From: Simon Davis
Sent: 15 March 2018 10:42
To: Planning Scanning
Subject: FW: Y/8/18/PL - Adjacent to The Old Malt House Main Road Yapton

From: Simon Davis
Sent: 15 March 2018 10:41
To: [REDACTED]
Subject: Y/8/18/PL - Adjacent to The Old Malt House Main Road Yapton

block plan 1:500@A3

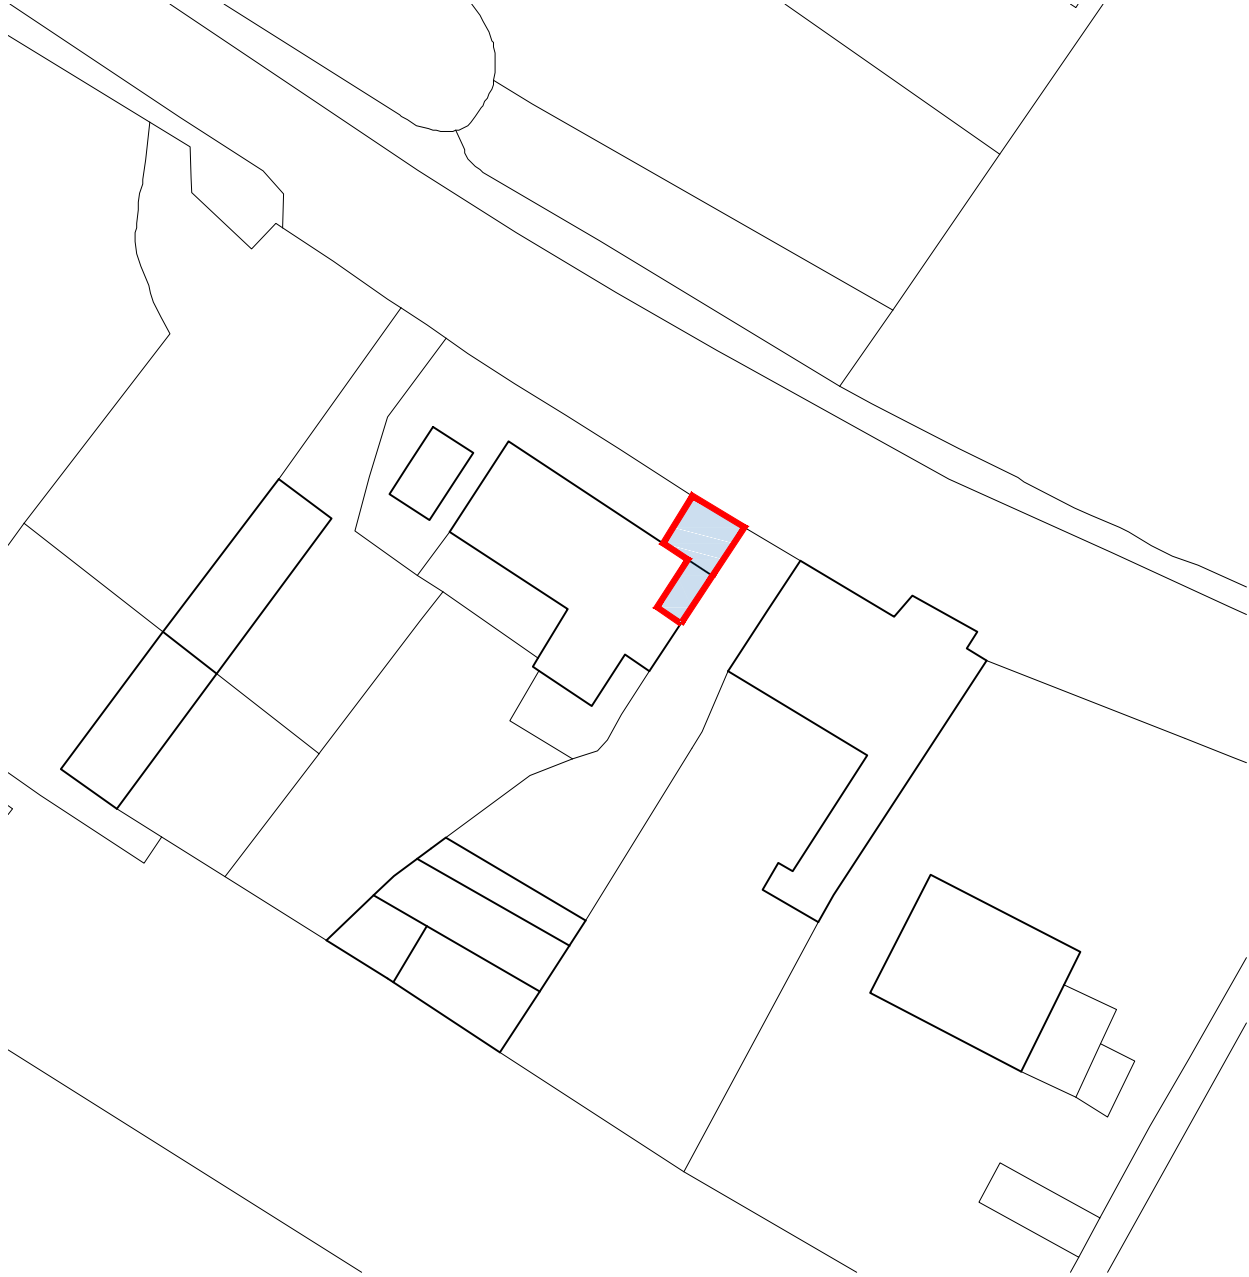
Please see attached response from Yapton Parish Council. Is it possible to allocate some off-street parking for this holiday unit?
